# PAINT BRUSH HILLS FILING 13E

### CONSTRUCTION PLANS

JULY 2018

PCD PROJECT NO. SF-18-005

PAINT BRUSH HILLS FILING NO. 13E
CONSTRUCTION PLANS
KEY MAP WITH SIDEWALK LOCATIONS
INCLUDING TYPICAL ROAD SECTIONS

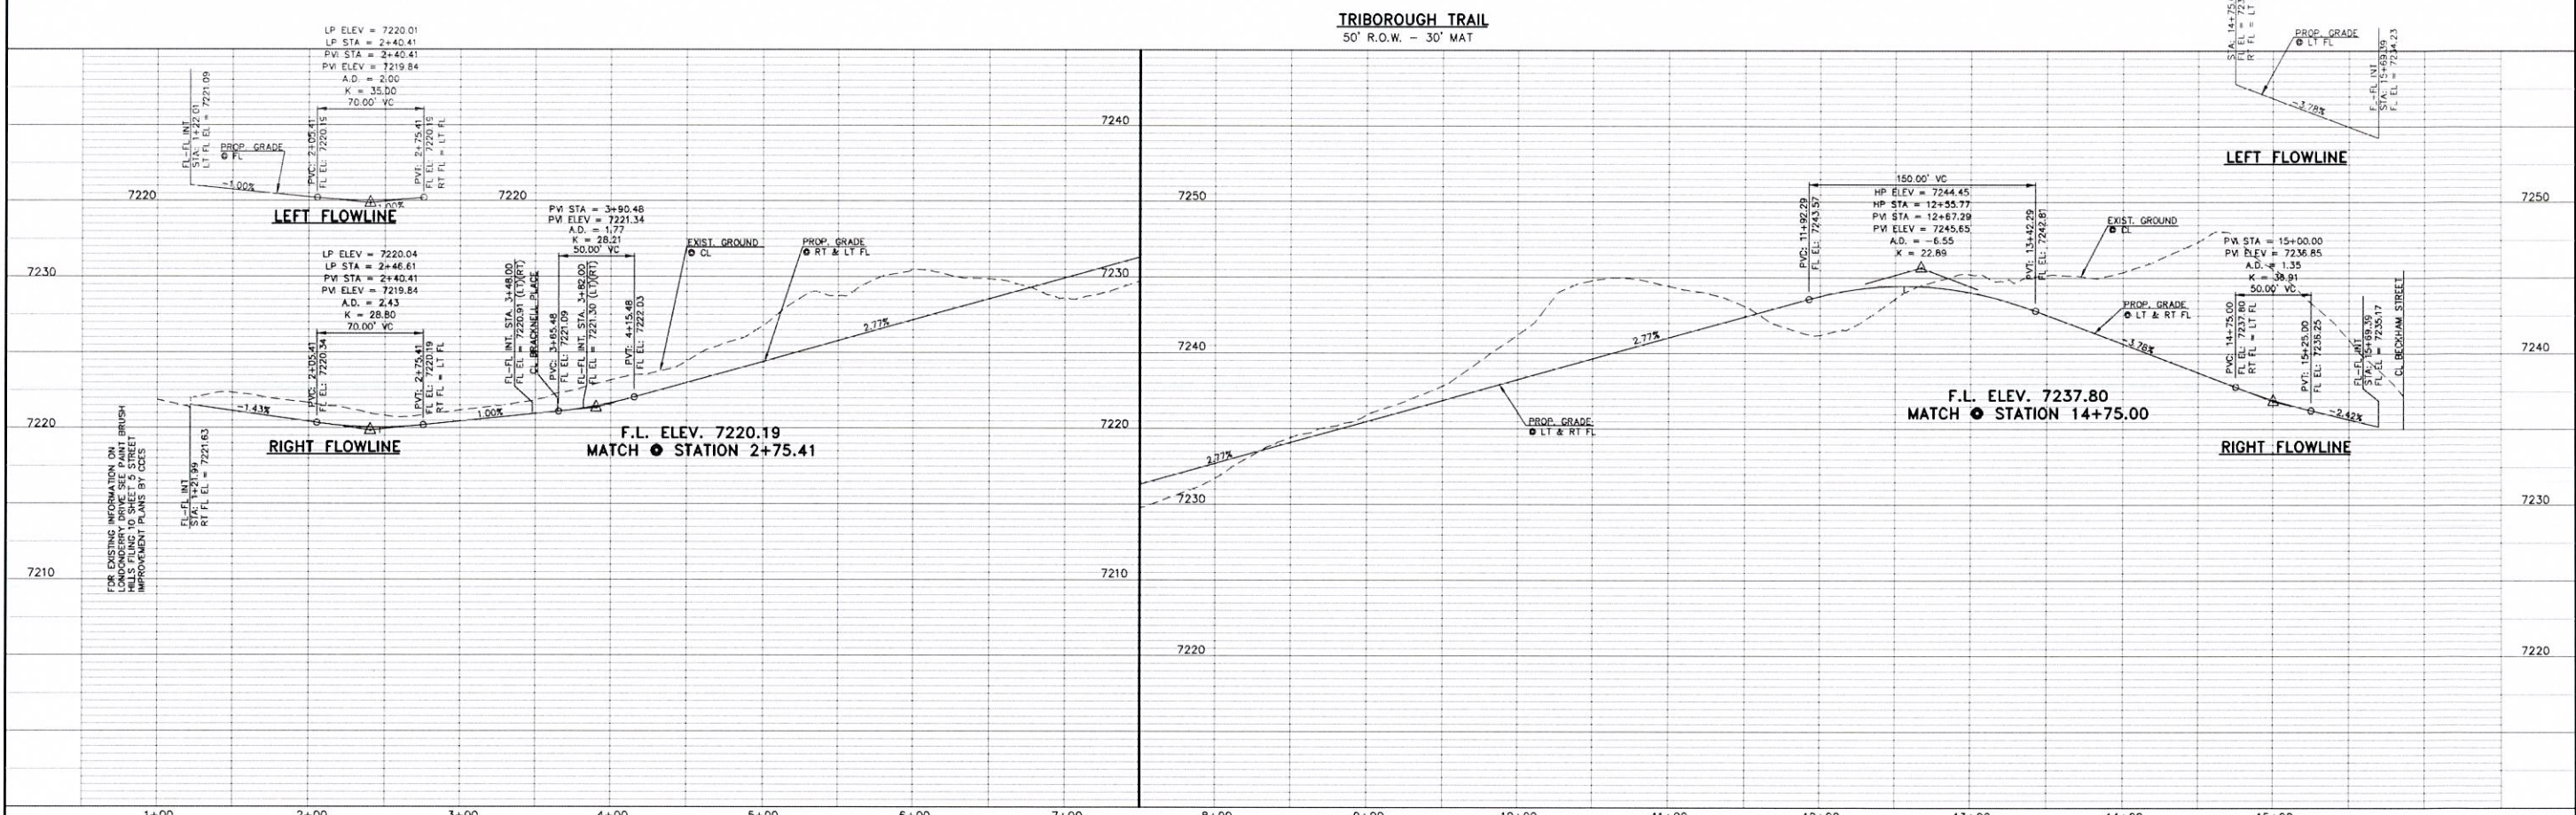
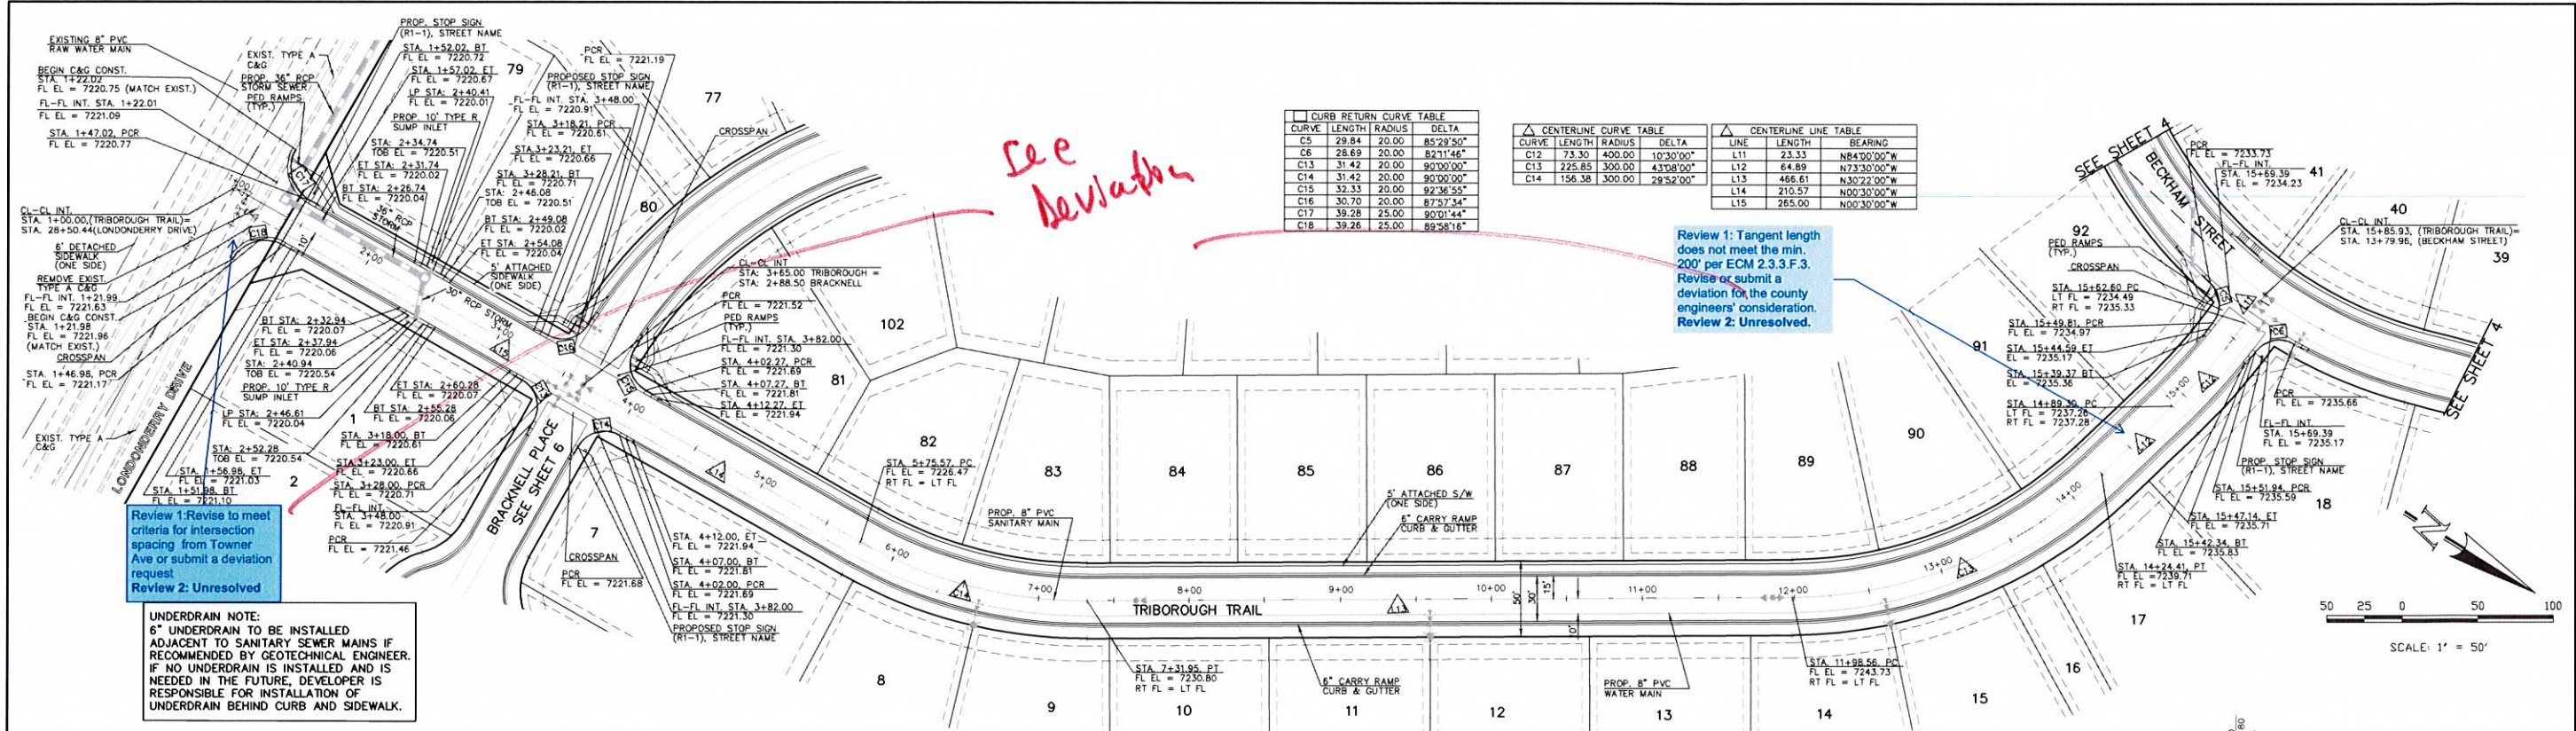
*See new sheet 2*

*Provide typical roadway cross sections*

*Add sheet index.*

Provide a key map.

See sheet 2 new

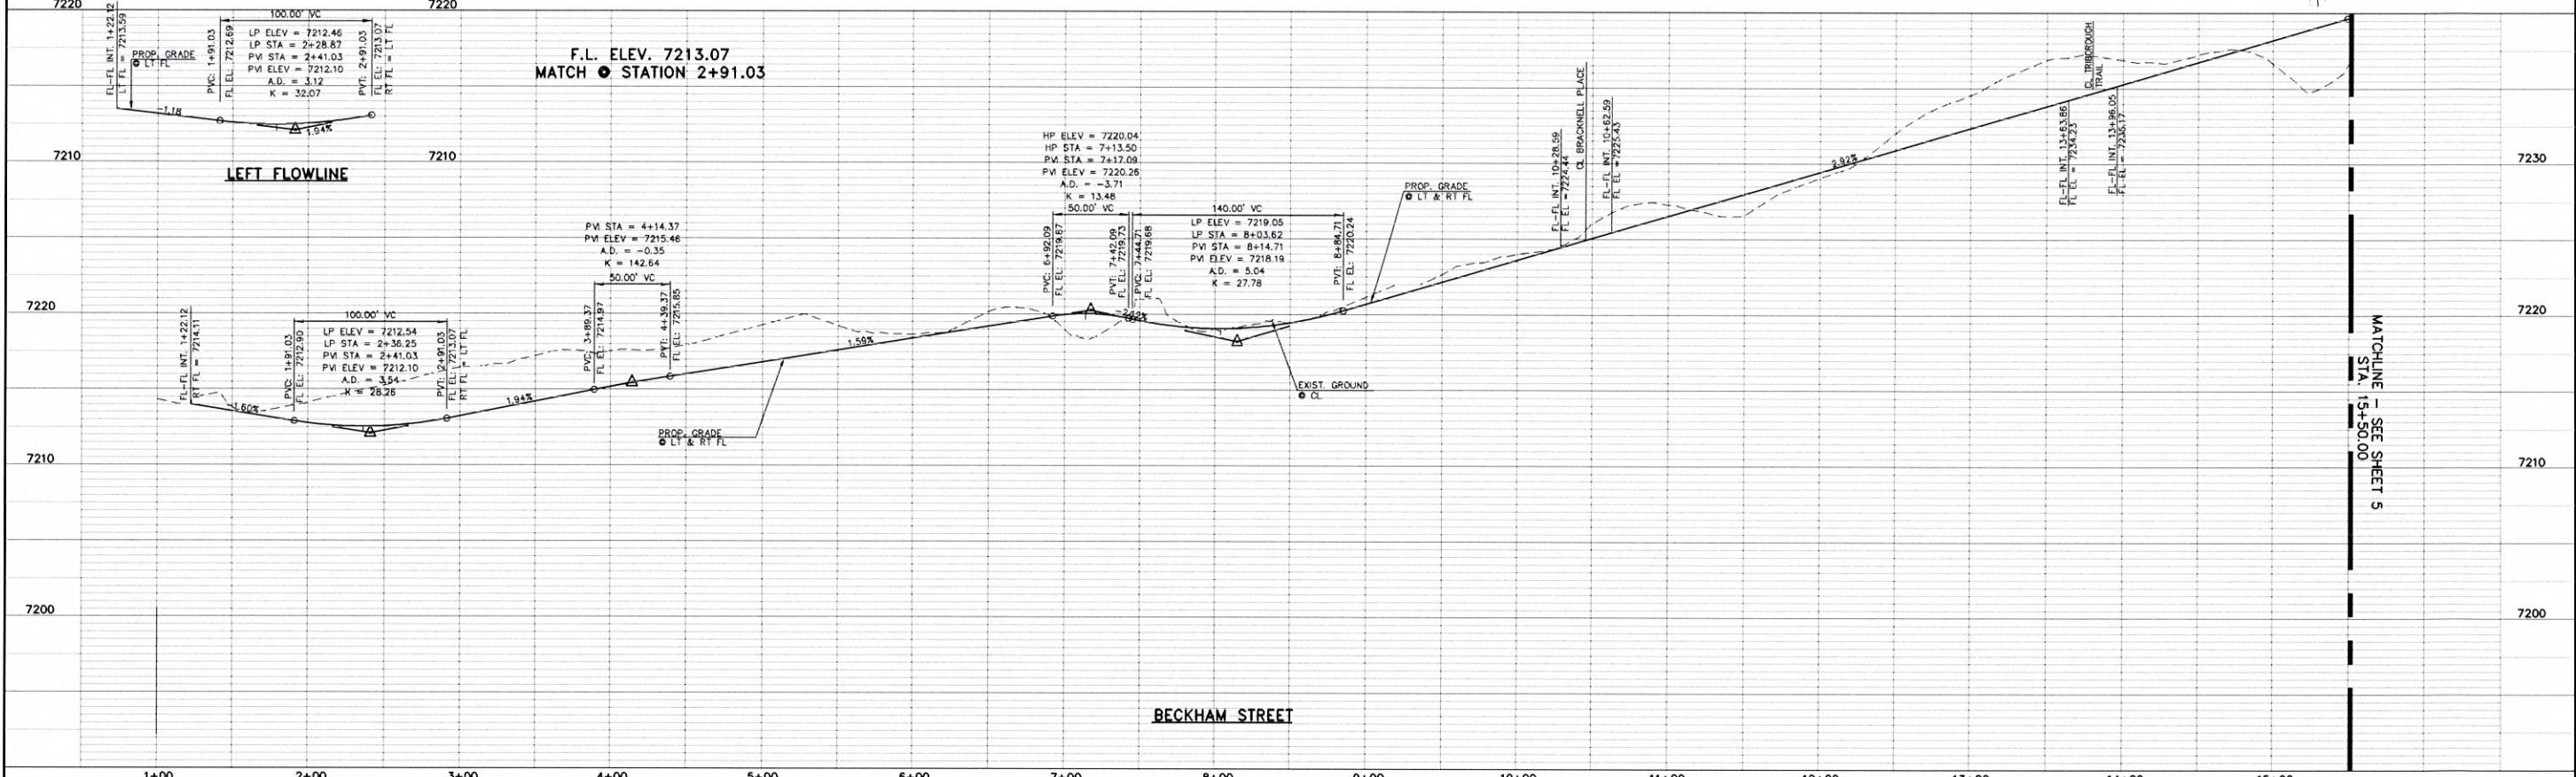
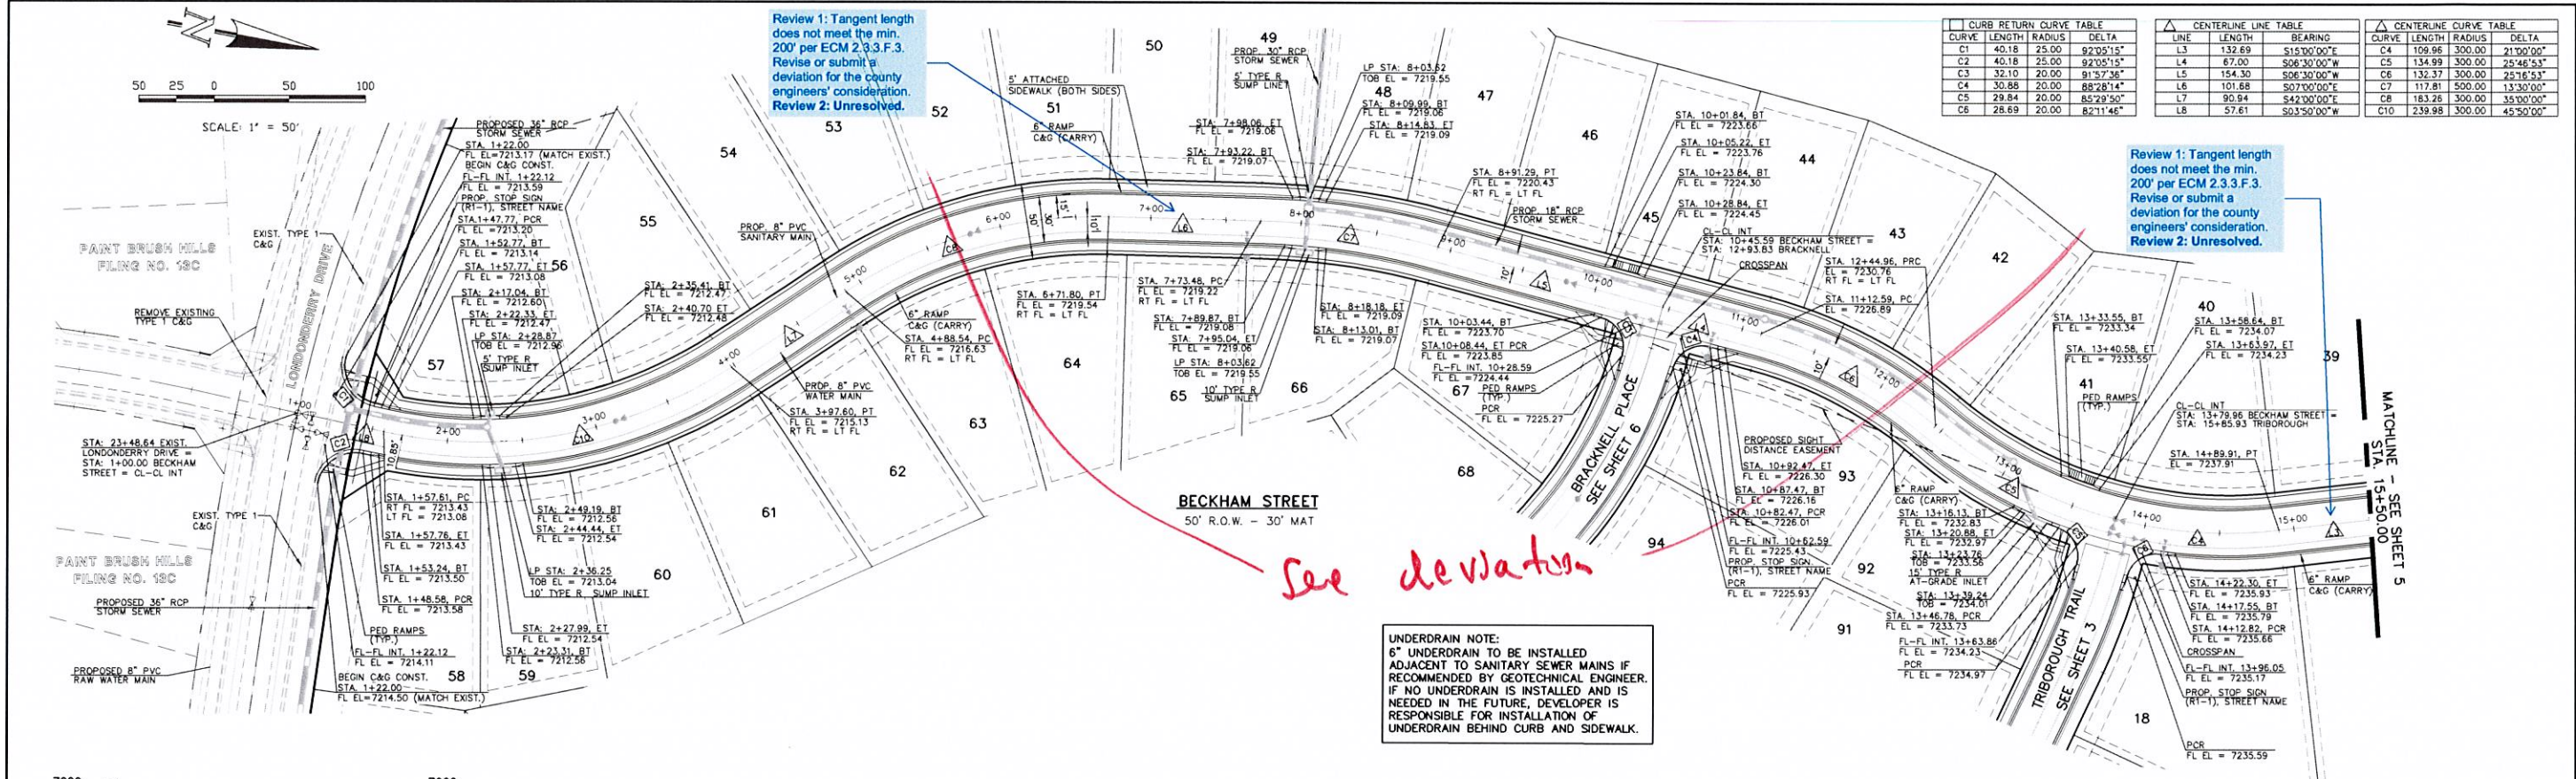
A geotech report was not included with the application. Design engineer to verify if the report included recommendations to provide underdrain.

If no underdrain is provided then add a note that if underdrain is needed in the future then it shall be installed by the developer behind the sidewalk. This will be identified as either a notation or condition of approval.

Tangent length does not meet the min. 200' per ECM 2.3.3.F.3. Revise or submit a deviation for the county engineers' consideration.

Revise. Per ECM Detail SD 2-40 this needs to be a ROW and not a public improvement easement. Adjust all applicable intersections accordingly.

Revise to meet criteria for intersection spacing from Tower Ave or submit a deviation request

A waiver request was submitted with the original PBH 13 (SF05038) to exclude sidewalk on the east half of specific roadways. Due to the proximity to the school it is highly recommended that sidewalks be installed on both sides of all proposed internal local roads.

Original plat approved by BOCC

Int. spacing approved w/ Filing 13 Plat by BOCC.

Based on original plat approval by BOCC and to remain consistent w/ surrounding development as sidewalk provided adjacent to RS 20000 lots.
